<b>Application Ref:</b>	3/2021/0034	 Ribble Valley Borough Council <a href="http://www.ribblevalley.gov.uk">www.ribblevalley.gov.uk</a>
<b>Date Inspected:</b>	~	
<b>Officer:</b>	RB	
<b>DELEGATED ITEM FILE REPORT:</b>		<b>REFUSED</b>

<b>Development Description:</b>	Prior notification application for a proposed agricultural access track at Moorgate Farm.
<b>Site Address/Location:</b>	Moorgate Farm, Moorgate Lane, Dinckley, BB6 8AN

Location Plan - 1:2500

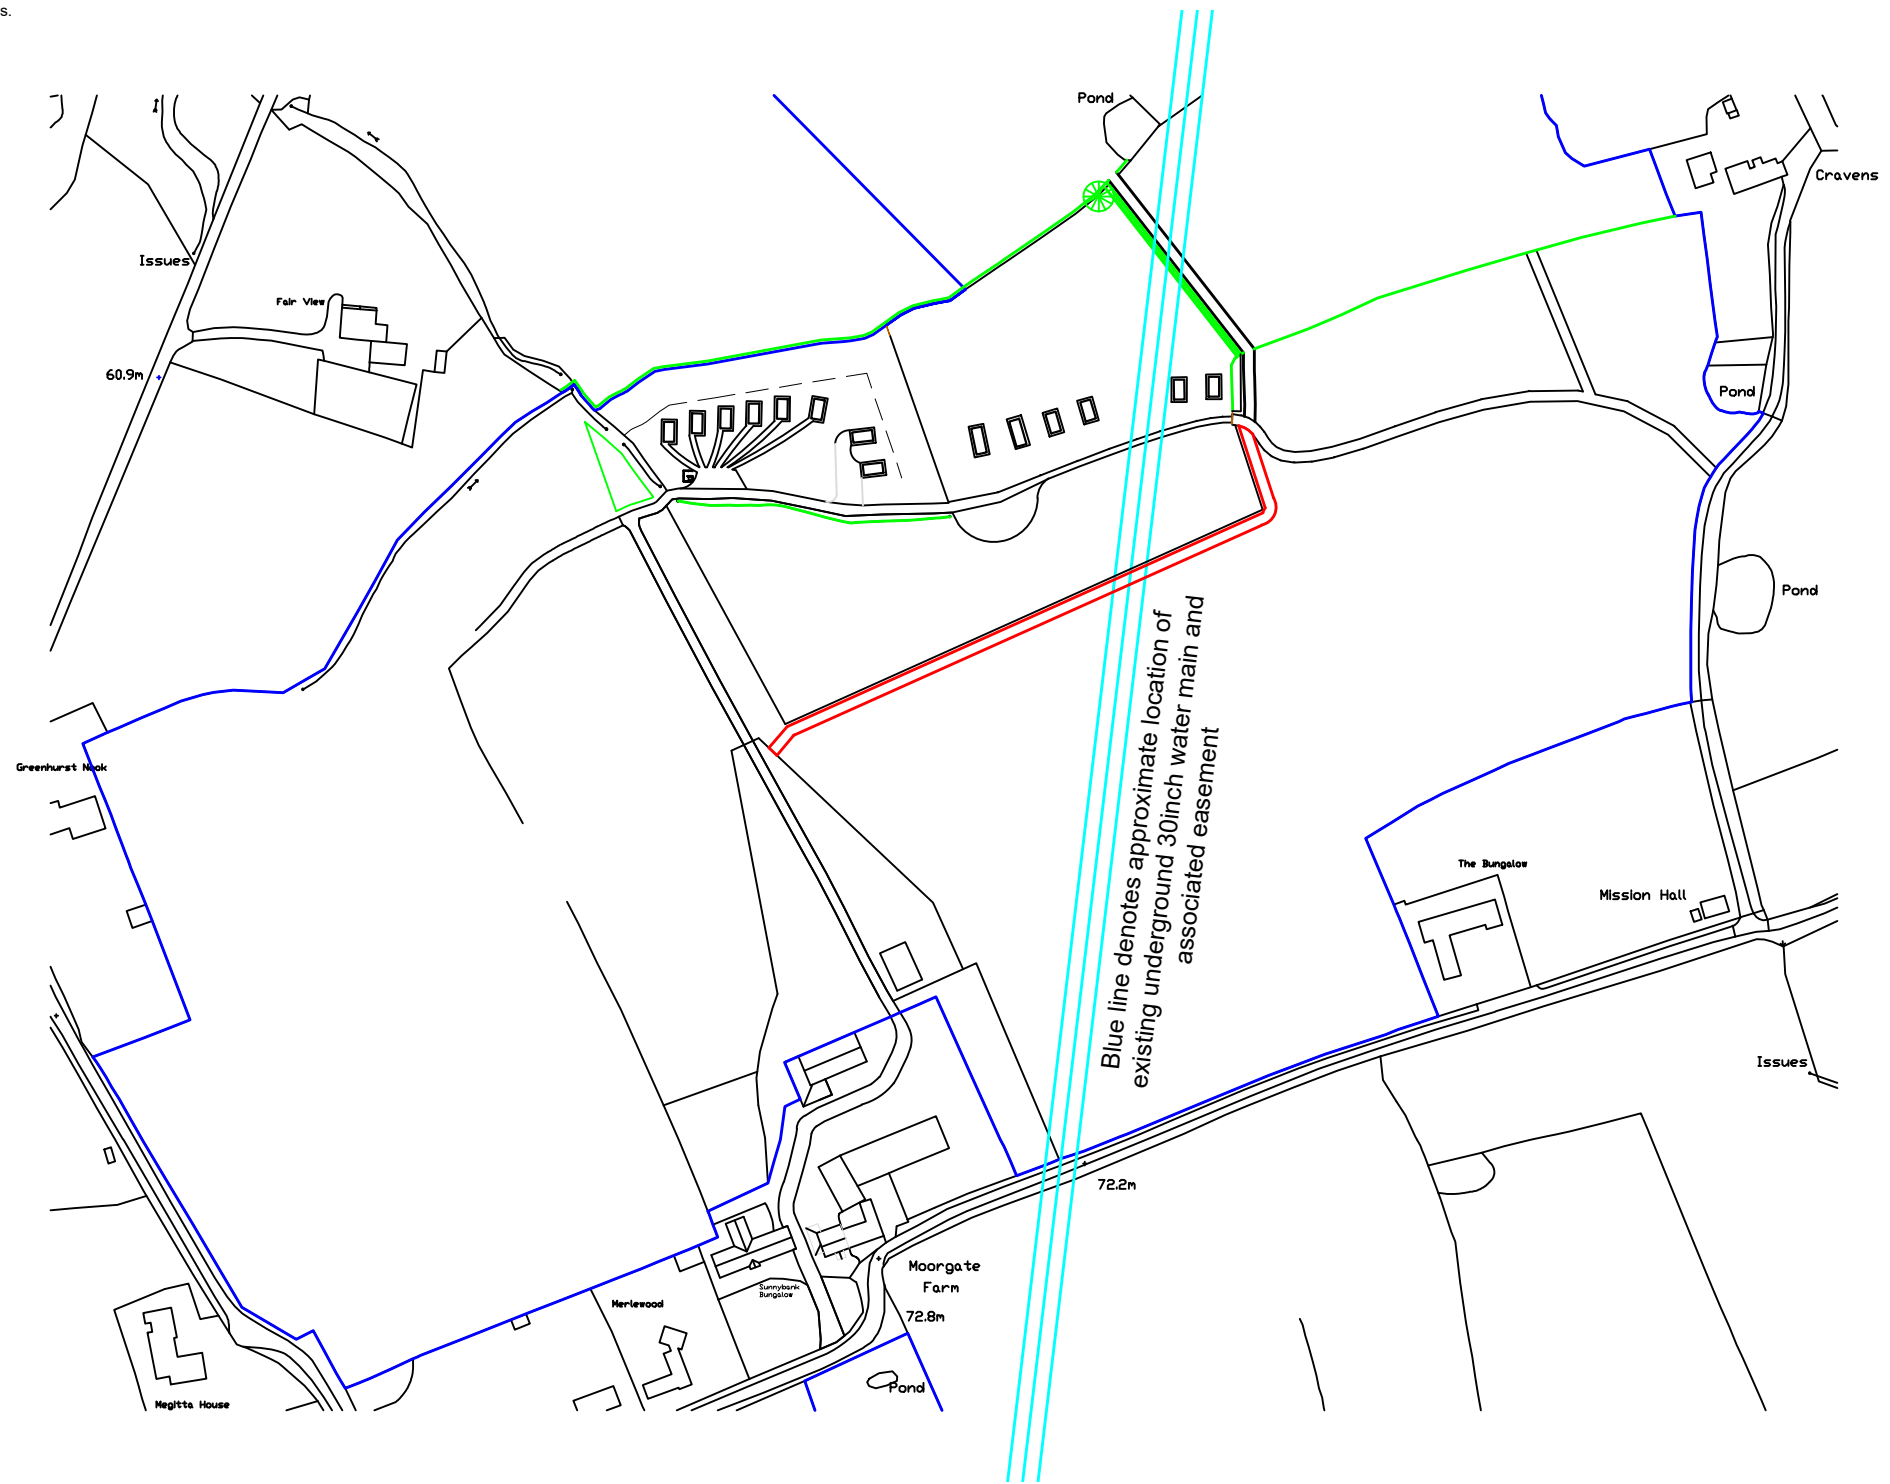
Furthermore, it is noted that an alternative route is also available to the approved agricultural track (3/2019/1006) via an existing track to the east of 'The Bungalow'.

Notwithstanding the above, even in the event that the LPA considered the track to be necessary for agricultural purposes it is considered that, by virtue of its siting and method of construction, and taking into account the location of surrounding tracks, the proposal would have a scarring effect on the landscape following neither established field boundaries or contours of the land.
